DRB Application No.: 02DRB-01754 (P&G)  
Project Name: **CROUCH'S SUBDIVISION**  
Agent: Harris Surveying Inc.

**CITY OF ALBUQUERQUE  
PLANNING DEPARTMENT  
Development Review Board Comments**

**Agenda Item:** 9     **Project #:** 1001937  
**Application #** 02DRB-01754

**Subject:**         **Crouch's Subdivision**

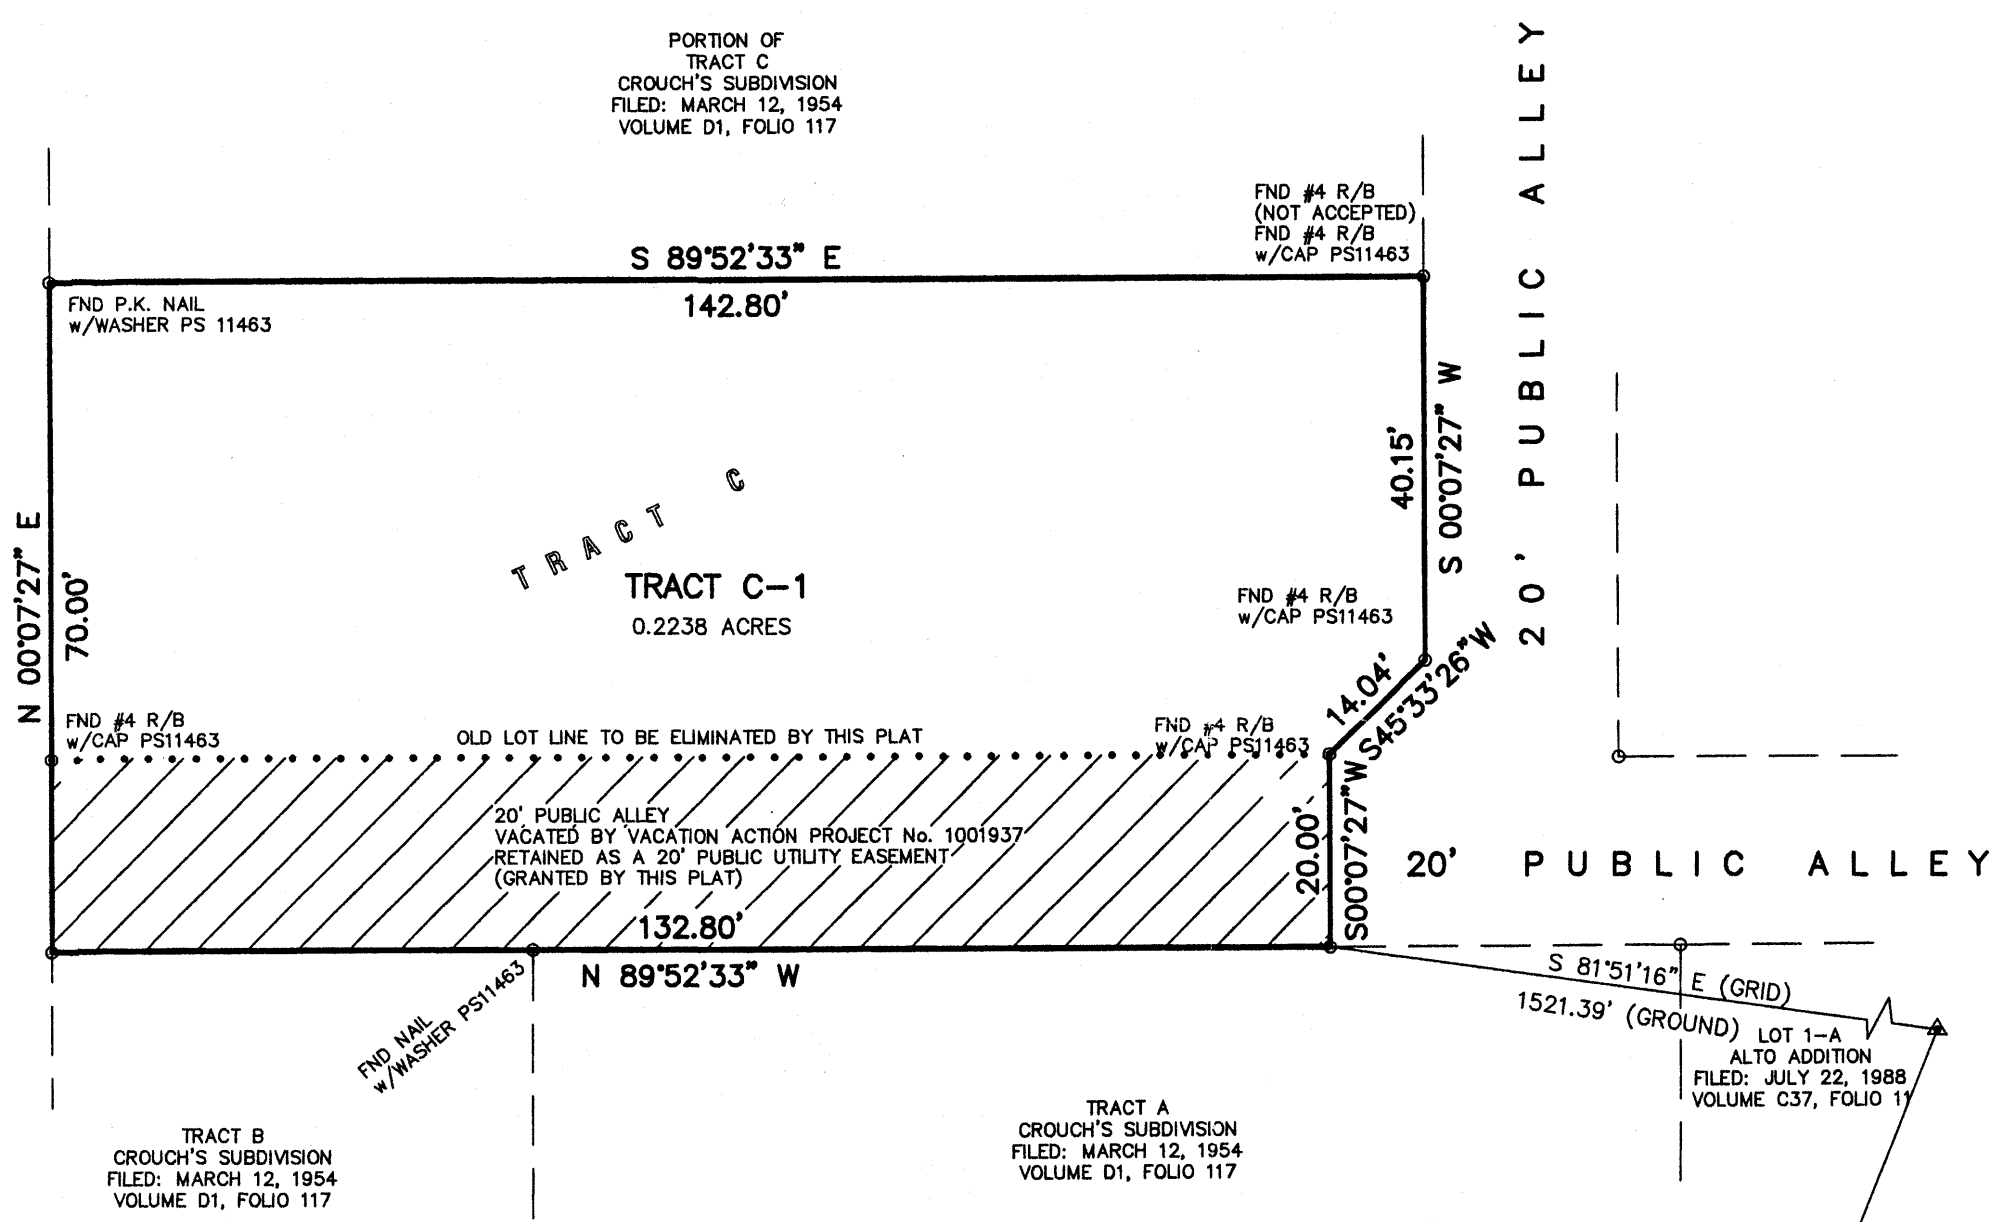
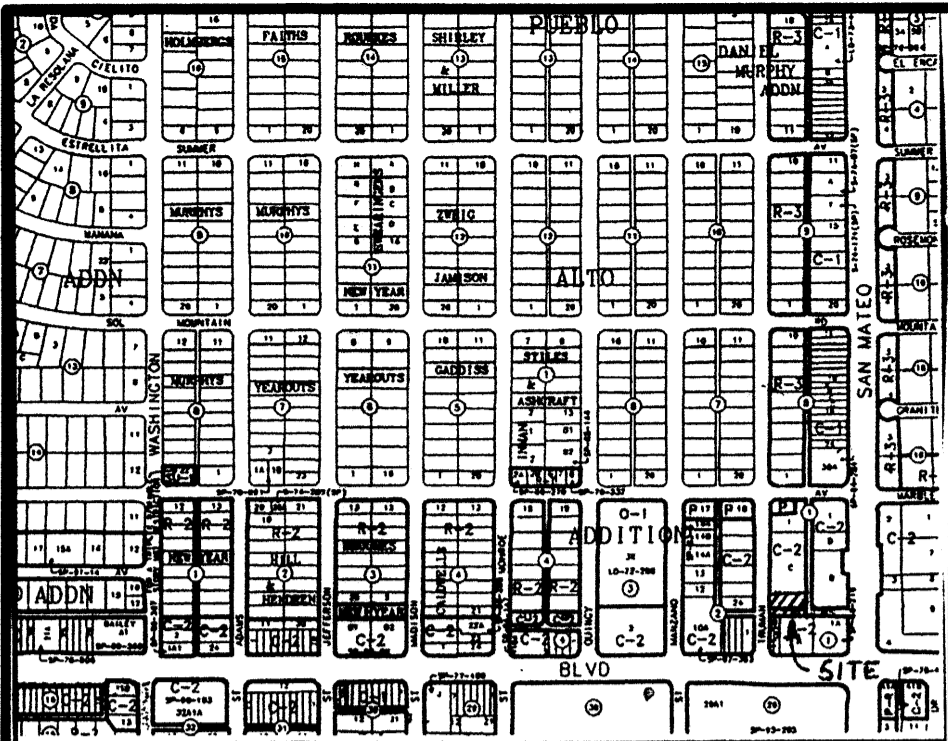
CITY ENGINEER / AMAFCA: Add note about ~~maintenence~~ steps that addresses public drainage easement and maintenance.  
 \_\_\_\_\_  
 \_\_\_\_\_  
 \_\_\_\_\_

CITY ENGINEER / AMAFCA: Add note about ~~public drainage~~ that addresses public drainage easement and maintenance.

Comment on plat concerning maintenance of drainage easement.
